CITY OF ALBUQUERQUE

November 20, 2018

**Re: McDonalds - 8315 Montgomery Blvd NE
Tract A-1-F of the Los Pastores Shopping Center
Grading and Drainage Plan - Engineer's Stamp dated: missing (F19D013A)**

GRADING PLAN

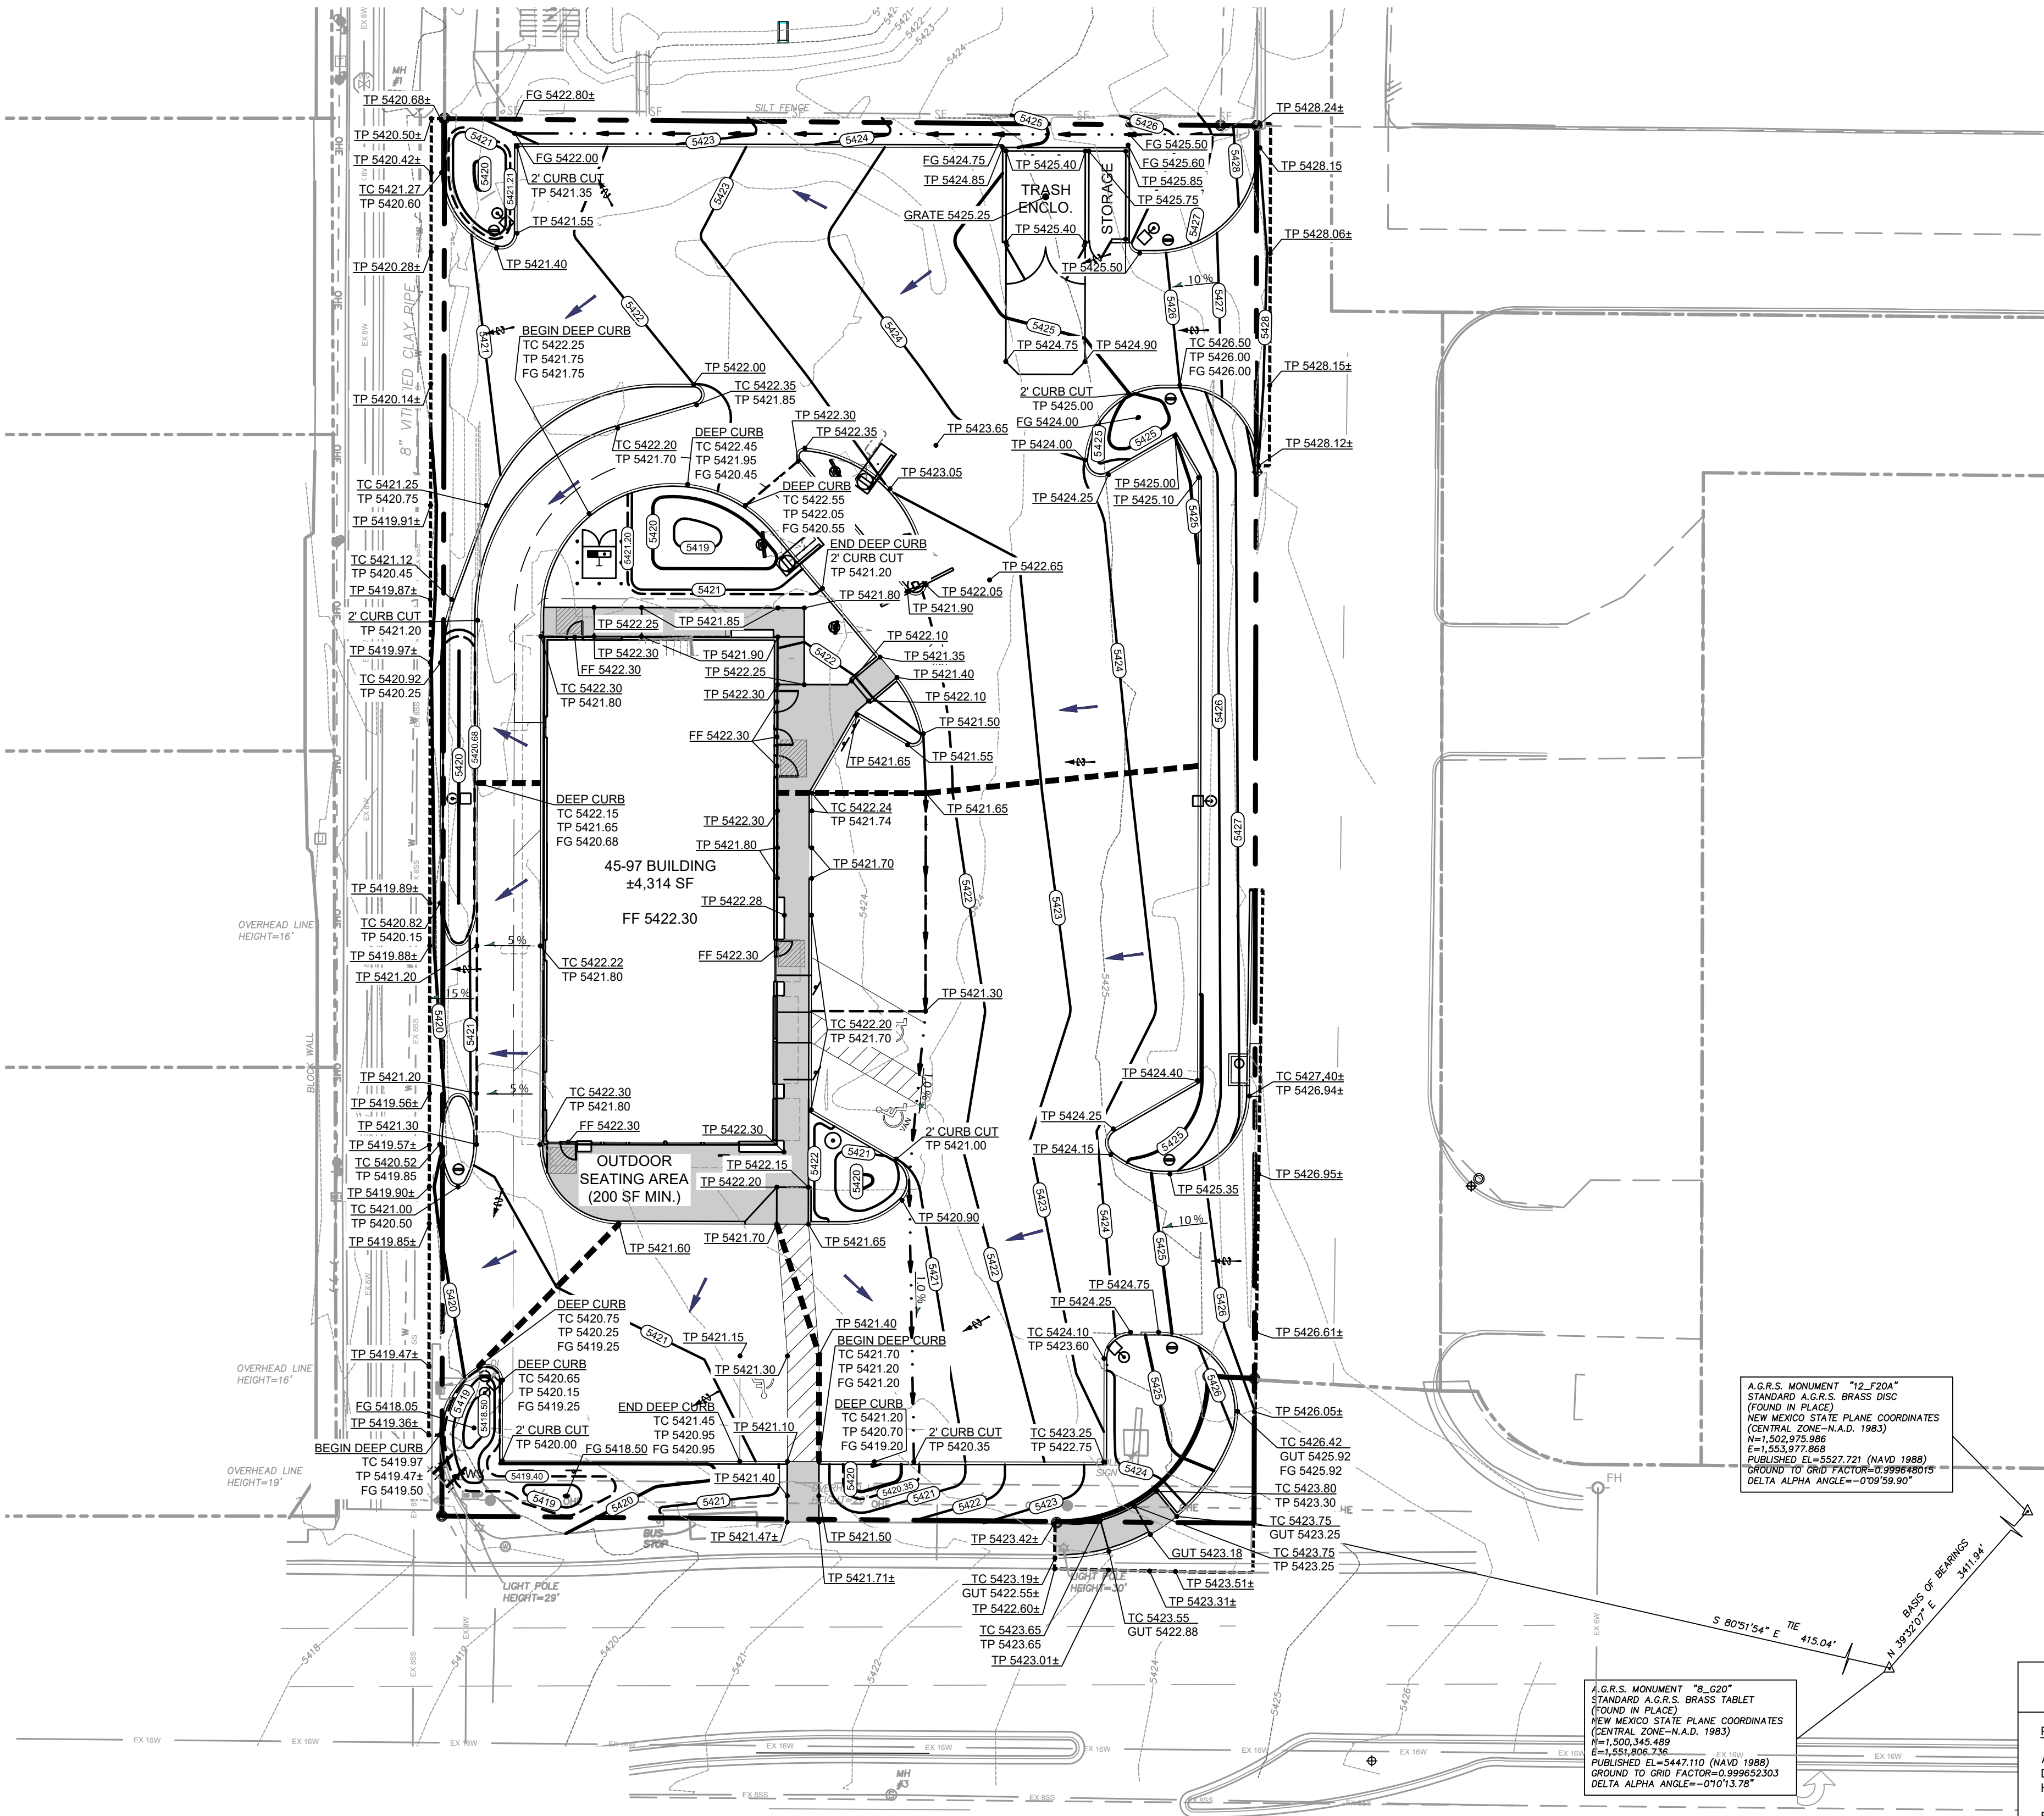
2. An engineer's stamp, signature, and date are required on the G&D Plan.
3. The floor elevation of the building must be set a minimum of 1.0' above the adjacent floodplain elevation. There is a Special Flood Hazard Area in Montgomery Blvd. It is an AO (depth 1 foot) zone which may have been rounded down from 1.4' feet depth. The street flow line elevation in front of the east edge of the building 5420.7 so the minimum floor elevation should be 5423.1. Please add a note addressing the floodplain, show the floodplain on the G&D Plan, show the floor elevation on the G&D plan and indicate the direction of the roof drainage. A floodplain development permit is required for any work in the floodplain.

7. Any portion of the peak 100 year flow rate that drains into Montgomery Blvd. will have to do so through appropriately sized sidewalk culverts. Use the weir equation to size the culvert not Manning's normal depth. The typical capacity is about 1.25 cfs per foot of opening, so two 2' wide culverts should be used. The sidewalk culvert must also extend all of the way from the curb to the right of way, and the invert should be specified at that location instead of the back of sidewalk. The culverts should be moved as far west as possible to the low corner of the pond.

9. A Private Drainage Easement and Drainage Covenant is required for the offsite storm drain on Tract A-1-E. It is near other easements which need to be shown and labeled on the plan as well as any conflicting utilities. Label Tract A-1-E, Access A, and A-1-D.

PRE-DEVELOPED DRAINAGE PLAN

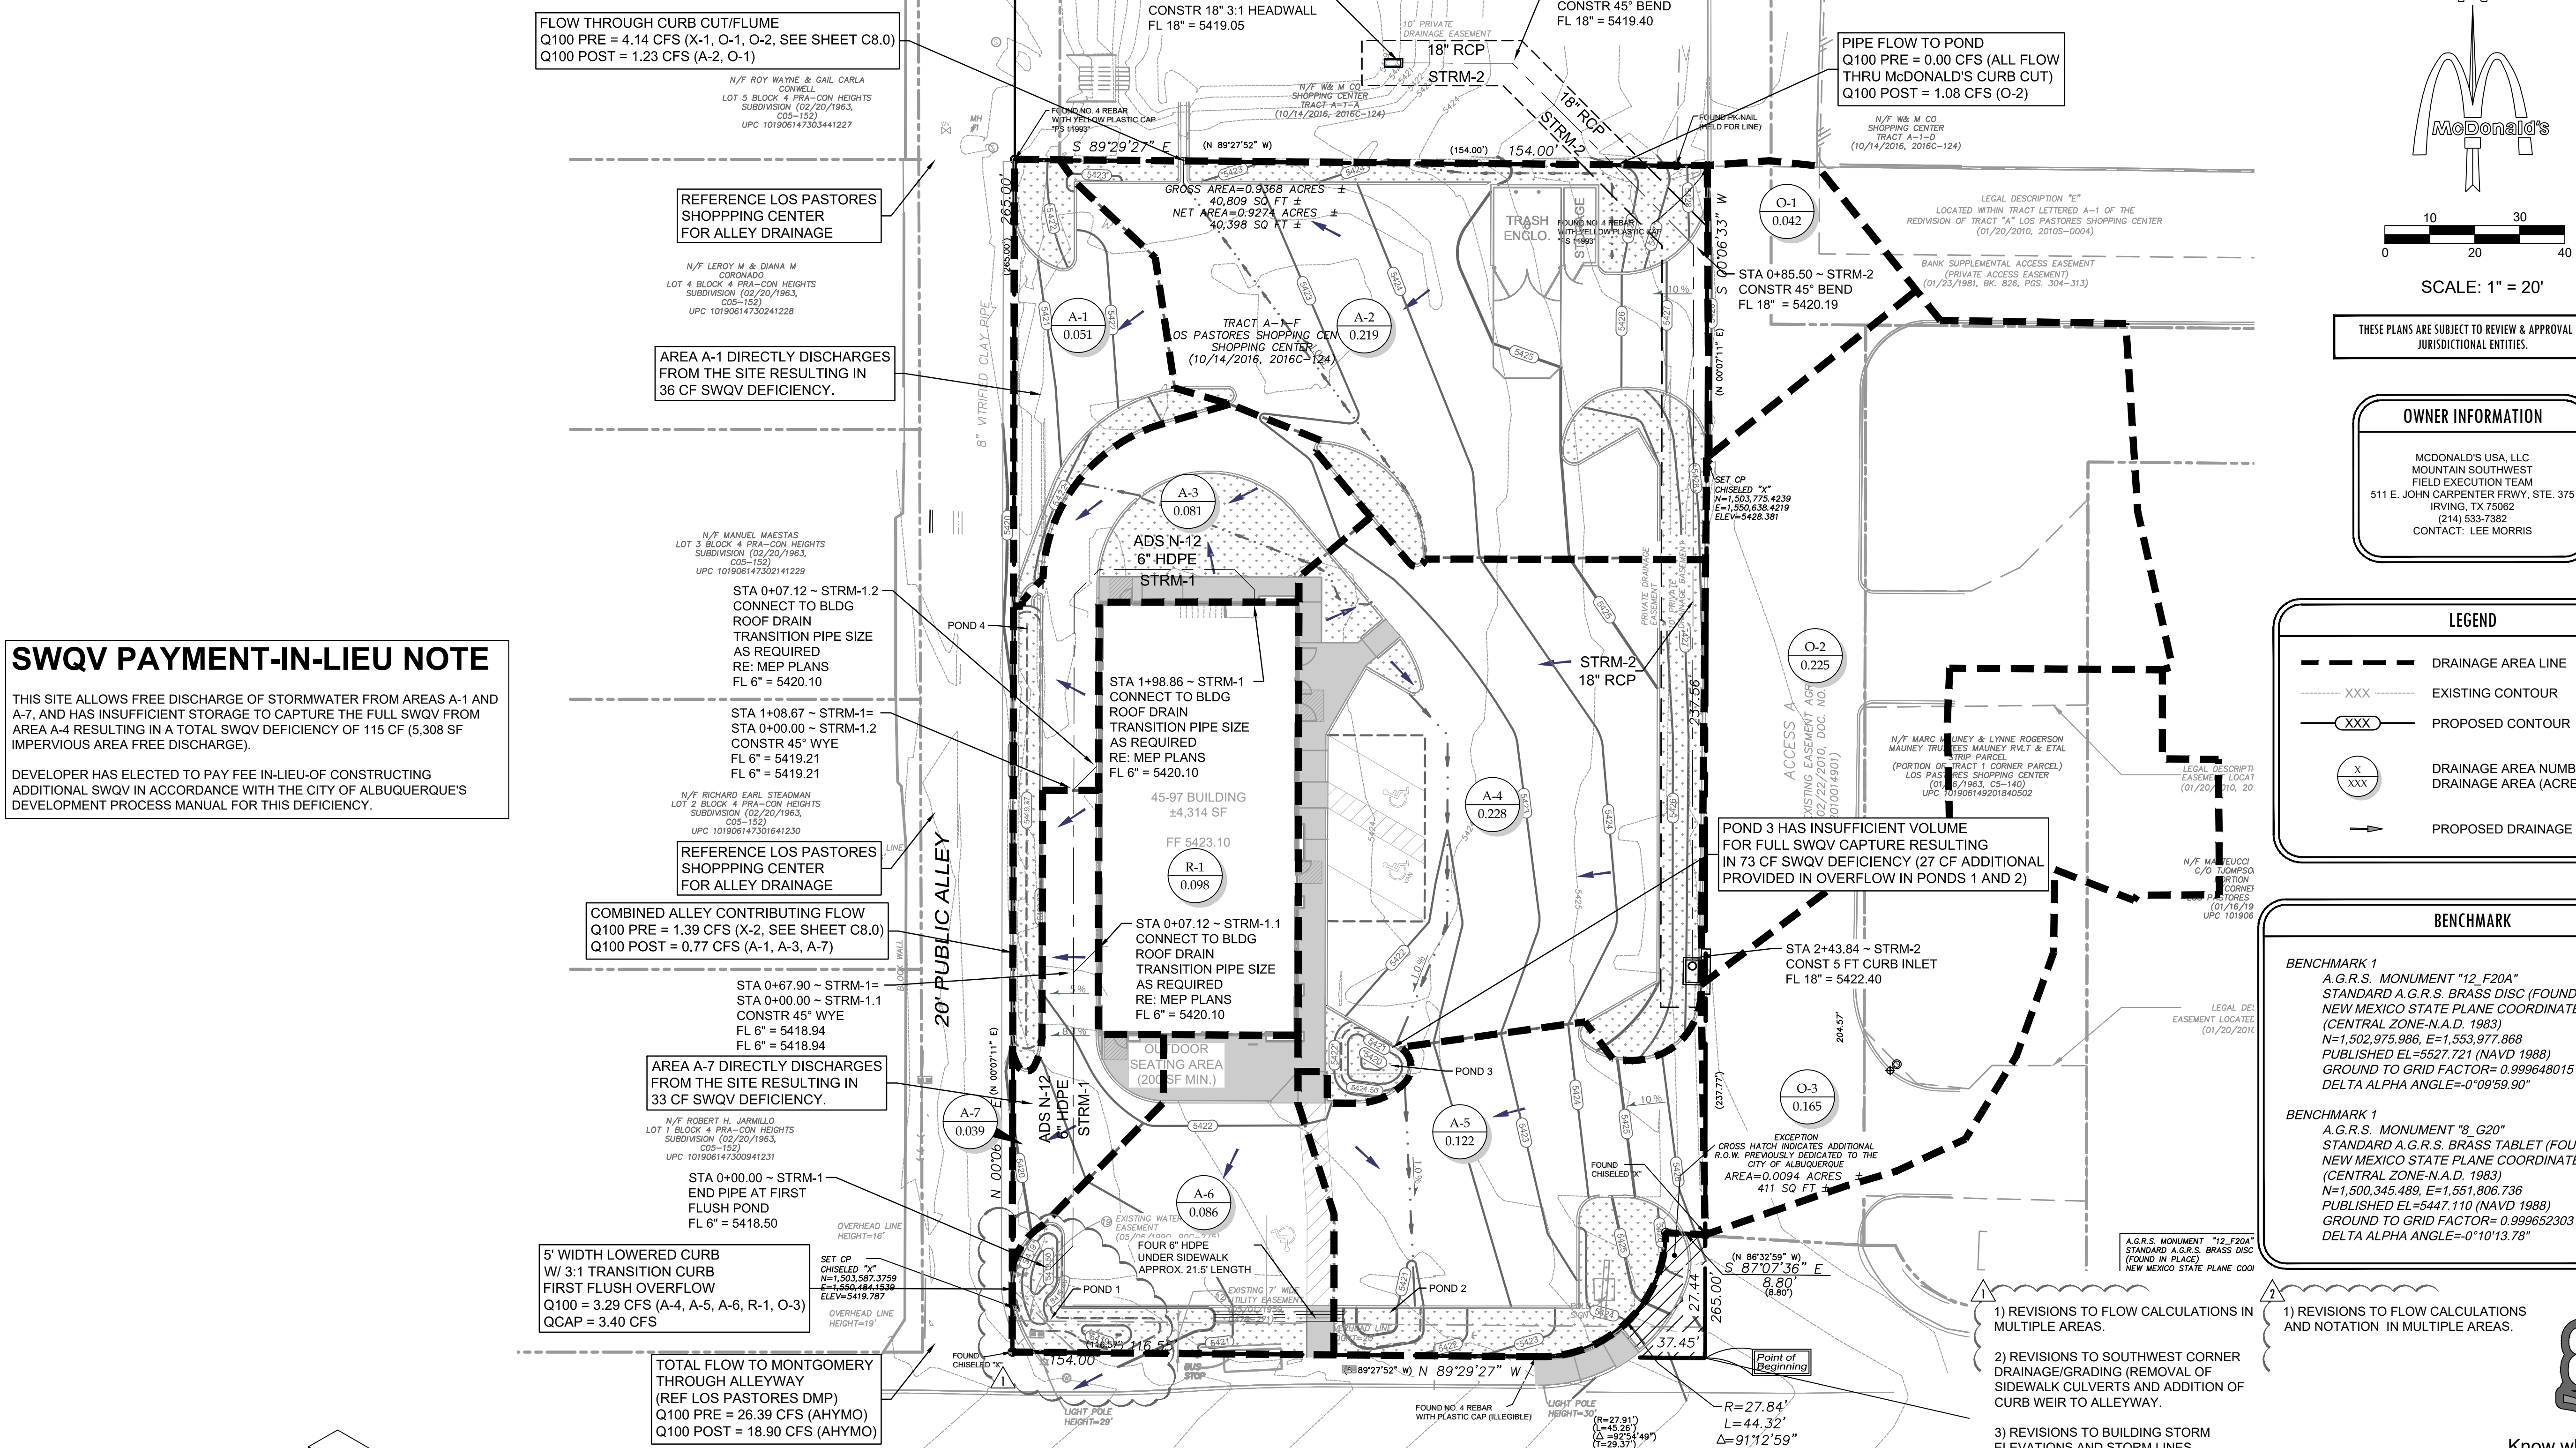
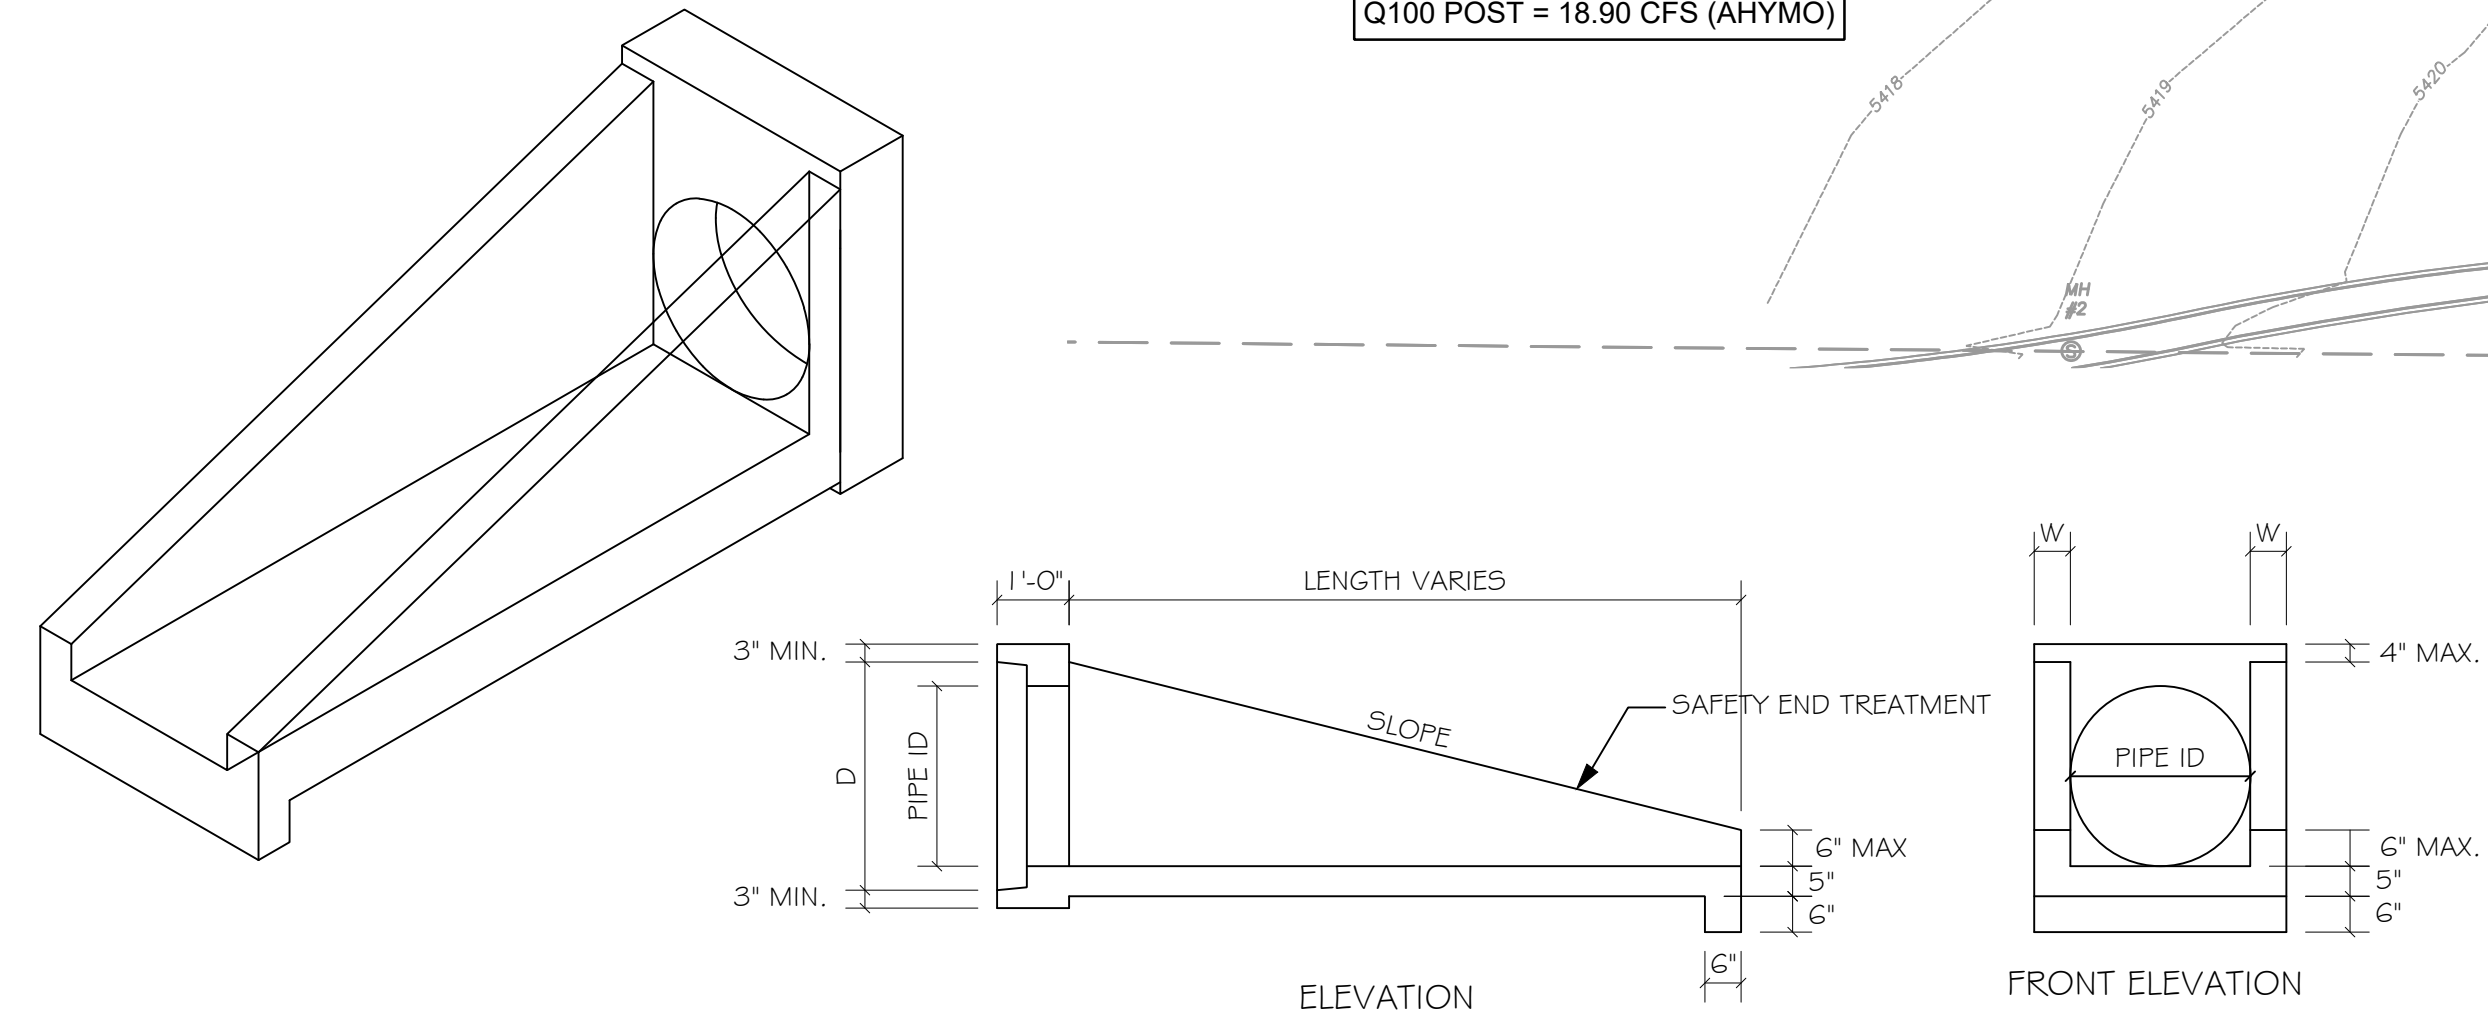
4. The alley and Montgomery Blvd. both have limited drainage and the plan increases the peak rate of runoff to both. The City engineer cannot approve any development who's increased runoff exceeds the downstream capacity per § 14-5-2-12(G) [http://library.amlegal.com/nxt/gateway.dll/New%20Mexico/albuqwin/chapter14zoningplanningandbuilding/article5floodhazardanddrainagecontrol?f=templates\\$fn=default.htm\\$3.0\\$vid=amlegal:albuquerque_nm_mc\\$anc=JD_14-5-2-12](http://library.amlegal.com/nxt/gateway.dll/New%20Mexico/albuqwin/chapter14zoningplanningandbuilding/article5floodhazardanddrainagecontrol?f=templates$fn=default.htm$3.0$vid=amlegal:albuquerque_nm_mc$anc=JD_14-5-2-12) The Drainage Management Plan for the Los Pastores Shopping Center (Hydro# F19D013C) established an allowable discharge of 26.47cfs from the 21.18 acres draining to the pond which equates to 1.25 cfs/acre. The 0.6 acre portion of this site that currently drains to the Los Pastores Pond only contributes 0.75cfs to Montgomery after going thru the pond, but that area will contribute 2.86 cfs Montgomery with the new plan. The existing floodplain on Montgomery indicates that it does not have capacity for any increased flow from this site. This site must either drain 0.6 acres to the Los Pastores Pond, or provide an equivalent onsite pond or some combination of those two.
